May 10, 2022

**Re: Peaks at Markana Phase 2 -
Erosion and Sediment Control Plan
Engineer's Stamp Date 5/6/2022 (B18E029)**

James D. Hughes, P.E.
Principal Engineer, Planning Dept.
Development and Review Services

TEMPORARY EROSION AND SEDIMENT CONTROL PLAN

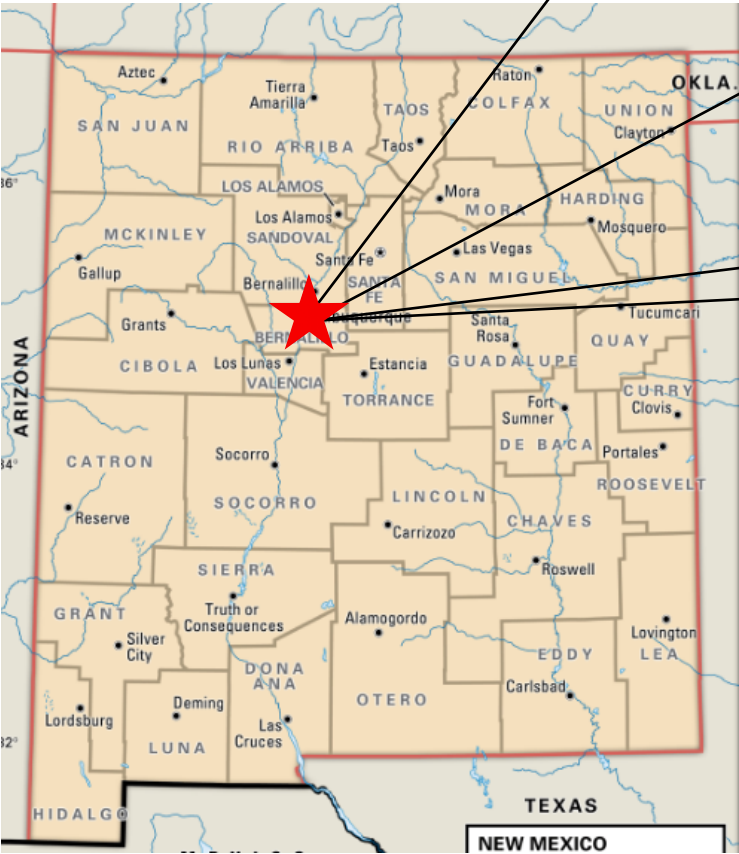
1. The existing screening fence is inaccurately shown on the south property line of this site. Instead the fence is located on the City's property about 30' to 40' south of the property line. The area of land disturbing activities and the staging area on City property must be added to the plan along with specifications for BMPs and Stabilization.

3. The limits of disturbance must include all Work Order improvements on Glendale from San Jose to the east side of this site, and disturbance on the City's property south of the site.(CGP7.2.4.b.i);

4. The ESC Plan can't be approved until after Hydrology approves the G&D Plan for each specific purpose Building Permit, and Work Order. The only purpose Hydrology has approved so far is Grading and Foundation Permit. The existing and proposed grades must be shown on the ESC Plan, and they must agree with the Grading Plan approved by Hydrology (CGP7.2.4.b.ii);

5. Stabilization measures (CGP 7.2.6.b.vi), including a) **Specific** vegetative and non-vegetative practices, b) deadlines, d) procedure to comply with The Weed Removal Ordinance (§ 9-8-1) must be identified. The landscape plan can be used to satisfy this requirement and should be included (on sheets separate from the ESC Plan) in the SWPPP and the ESC Plan submittal. Include specifications for the offsite areas of land disturbing activities as well.
6. Update the engineer's stamp date each time the plan is changed.
